# PAINT BRUSH HILLS FILING 14 RELIMINARY PLAN

## PAINT BRUSH HILLS FILING 14 PRELIMINARY PLAN

## 08/24/2020 EPC SUBMITTAL

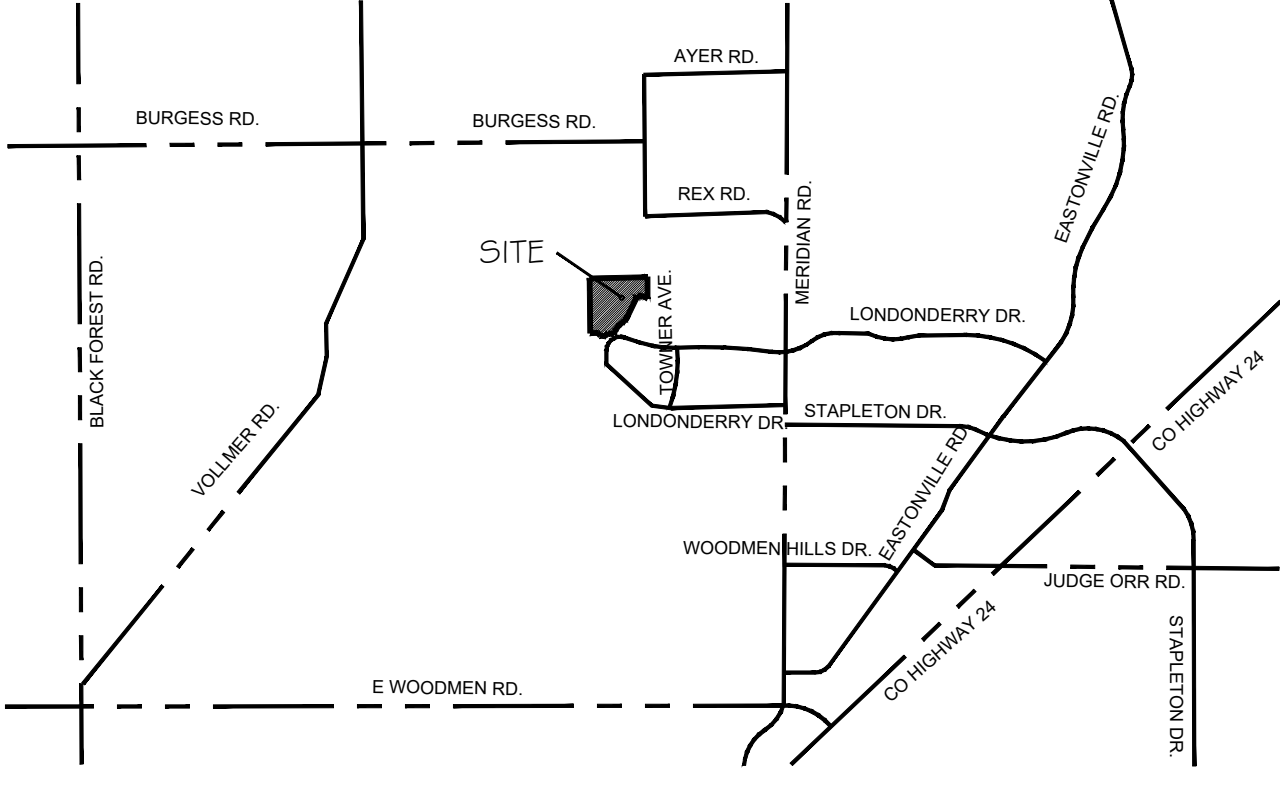
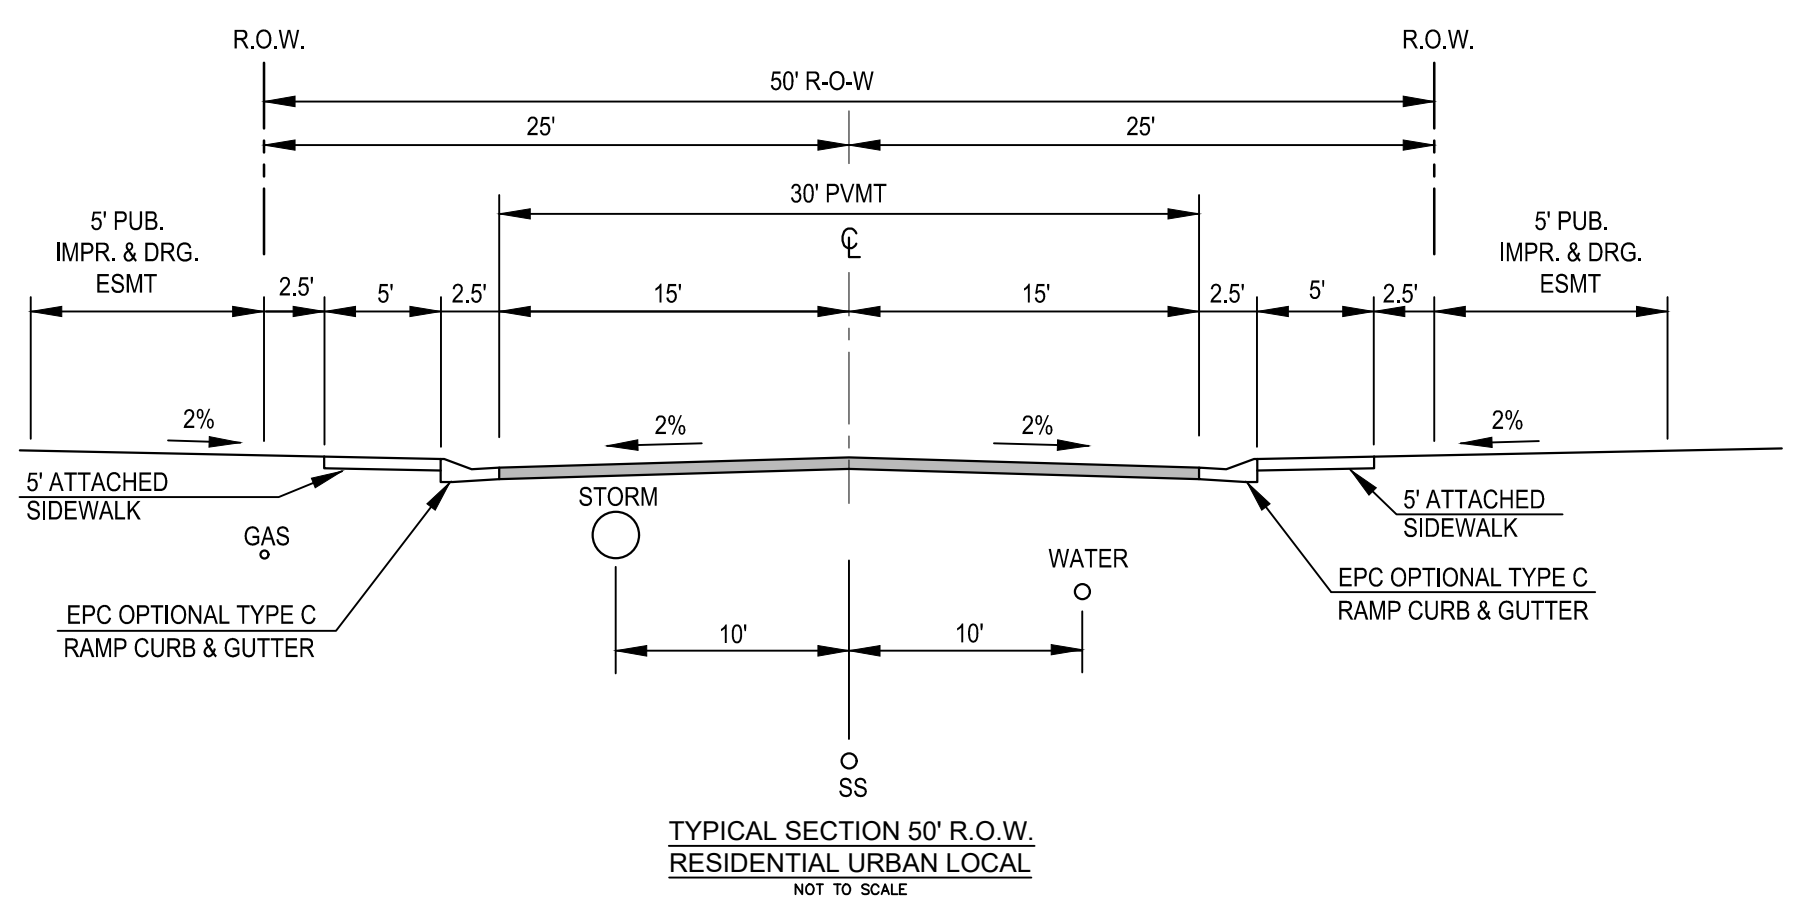
Revise to reflect mitigation required in the soils and geology report. Engineered foundation and perimeter or underdrains.

Add a legend and abbreviation list

For your information: ECM Detail SD\_2-2 only requires a 5' public improvement easement

Revise to "EPC Optional Type C"

Add "SP206"

PRELIMINARY GRADING PLAN

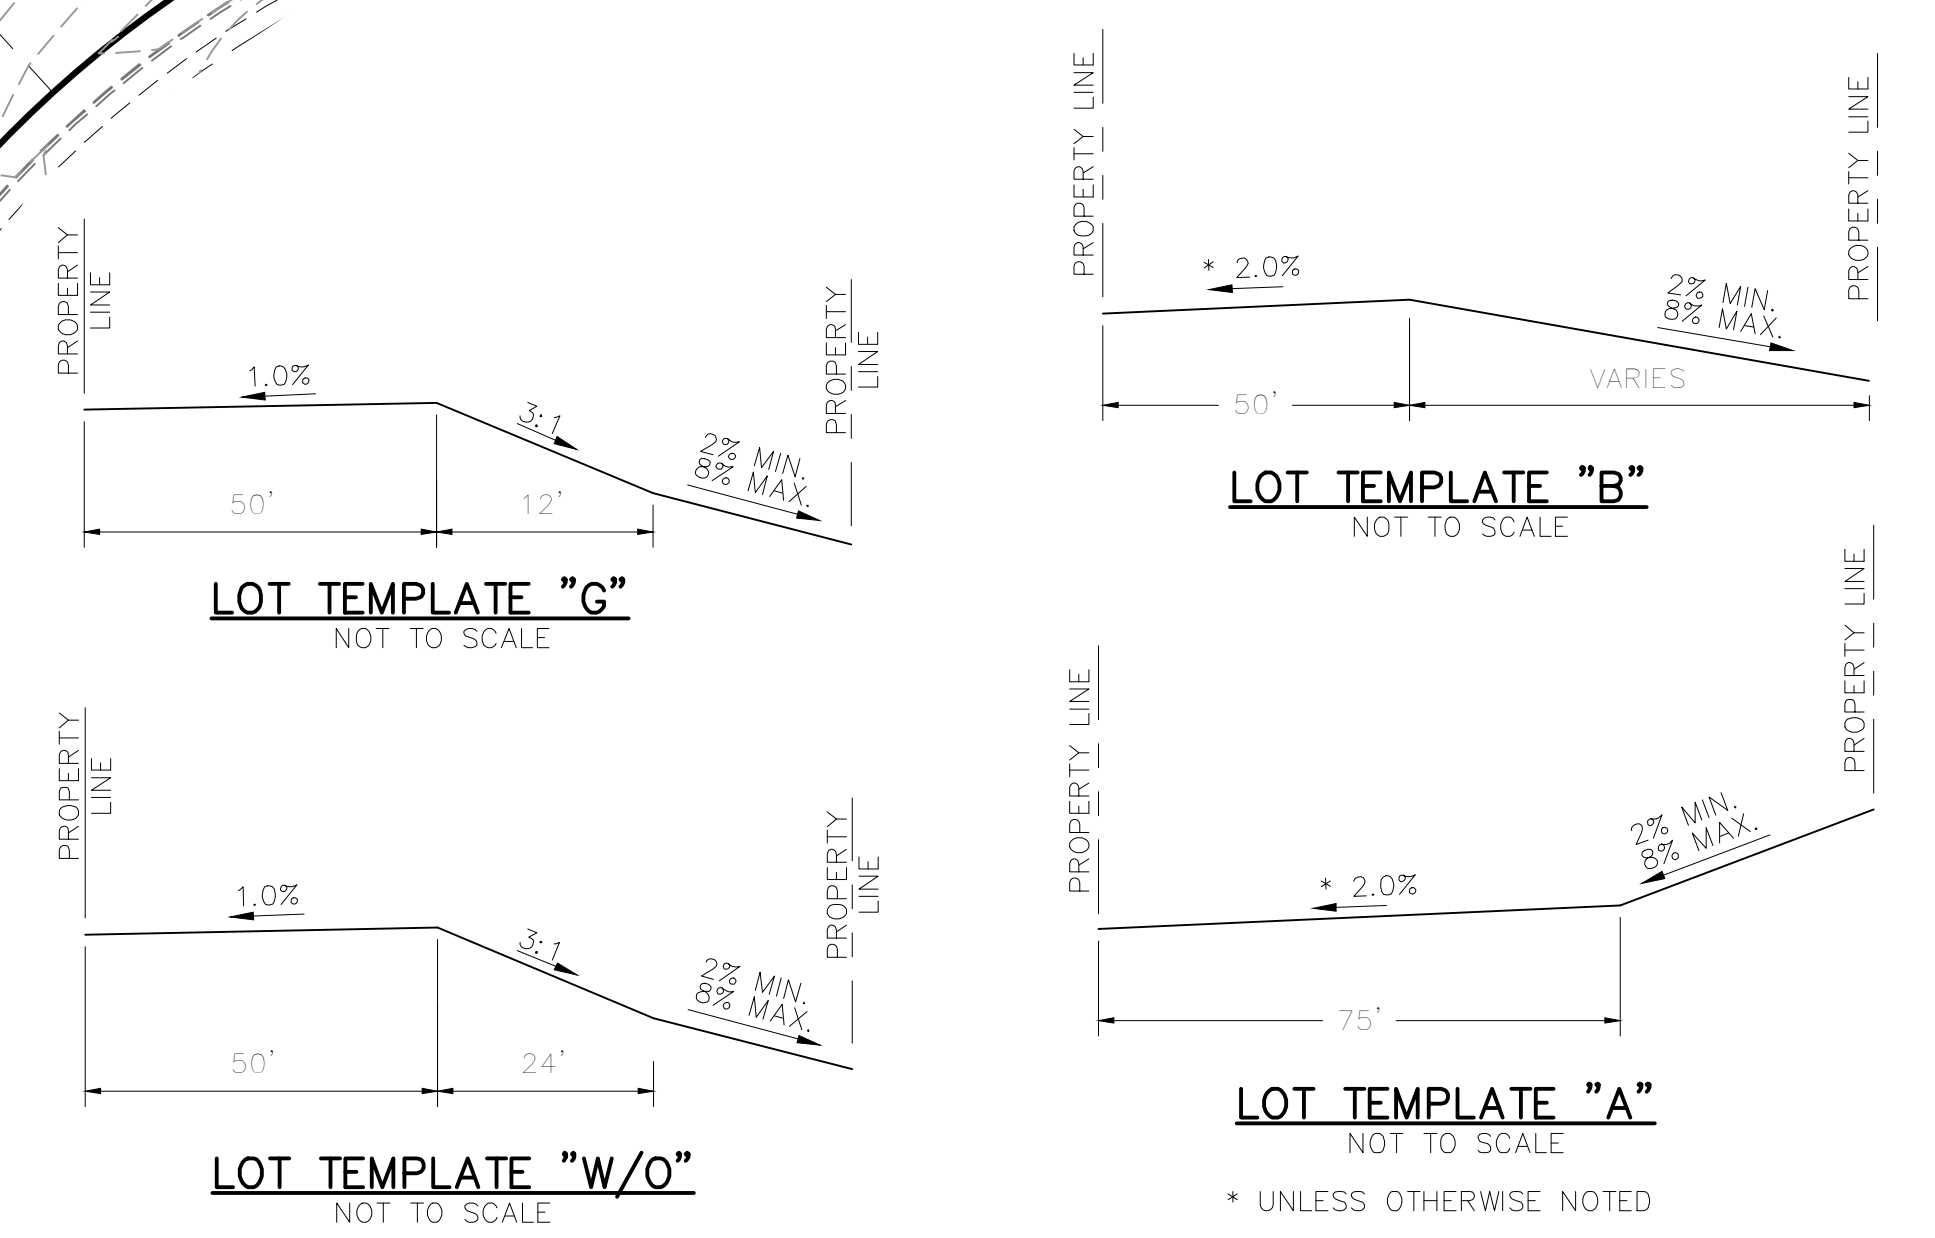
Based on the drainage report this drainage easement which also contains a drainage swale, therefore must include a restriction for no build and no storage of materials. Also update the final plat document to reflect the restriction.

Provide/Show maintenance access to the drainage swale and FES. A looped path or turnaround would need to be provided.

This existing swale should be filled if the drainage overflow is being routed within the proposed drainage easement.

Remove notes.

Remove temporary BMPs on the preliminary grading plan.
